Arborist Response

**Re: Royal Hall of Industries
Lot 3, (D.P.861843) and Lot 52 (D.P.1041134)
No. 1 Driver Avenue, MOORE PARK**

The following document provides a response to the request for additional information¹ regarding the application for the 'Adaptive reuse of the Royal Hall of Industries' (SSD-9726)¹. This document is based on the data provided in the Arboricultural Impact Assessment (referenced D3355, Date: May 2019) and related Addendum (referenced D3355A, Date: 18th October 2019). This response addresses Section 7 and 7.1 from the council document¹ and cites each Section and the response.

05
501 ROOF TERRACE - PLANTING CONDITION - SHRUBS AND GROUNDCOVERS SECTION
SCALE 1:10

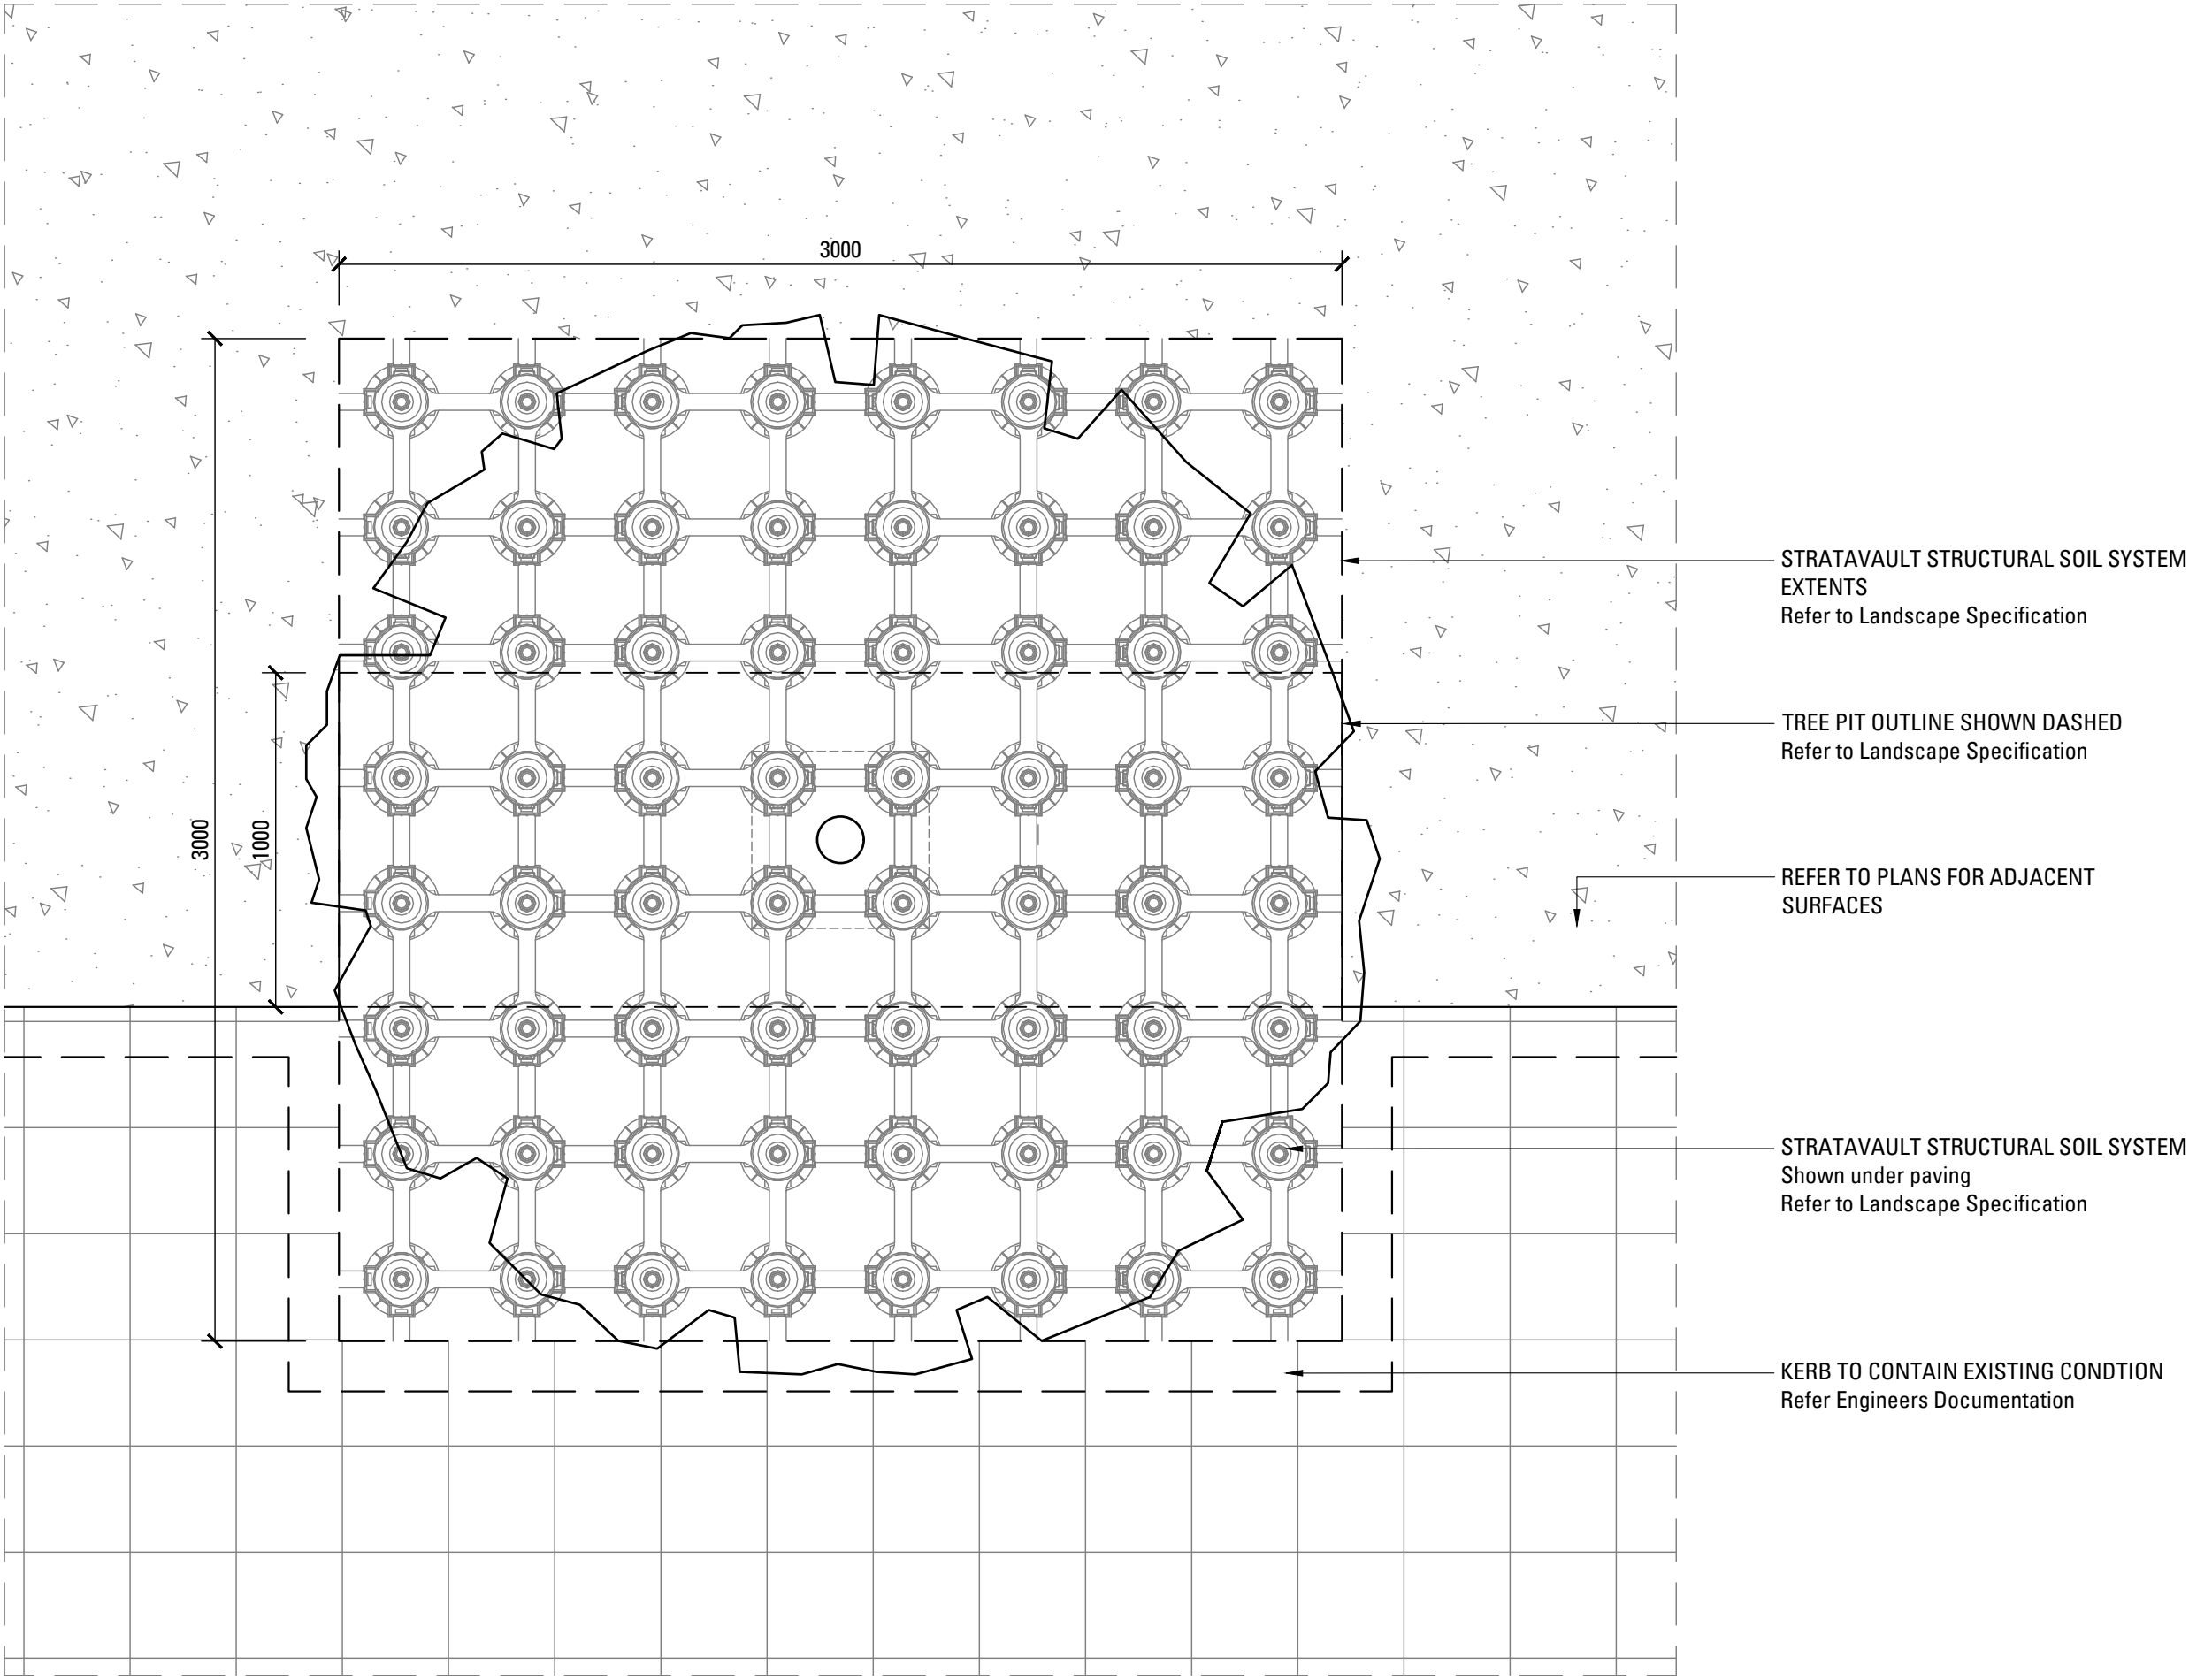
- e) *The Landscape Details indicate trees are planted into 'structural vaults'. The landscape plans do not clearly show where these vaults will be located*

This has been included in the Landscape drawing by *Arcadia*, January 2020, Issue G.
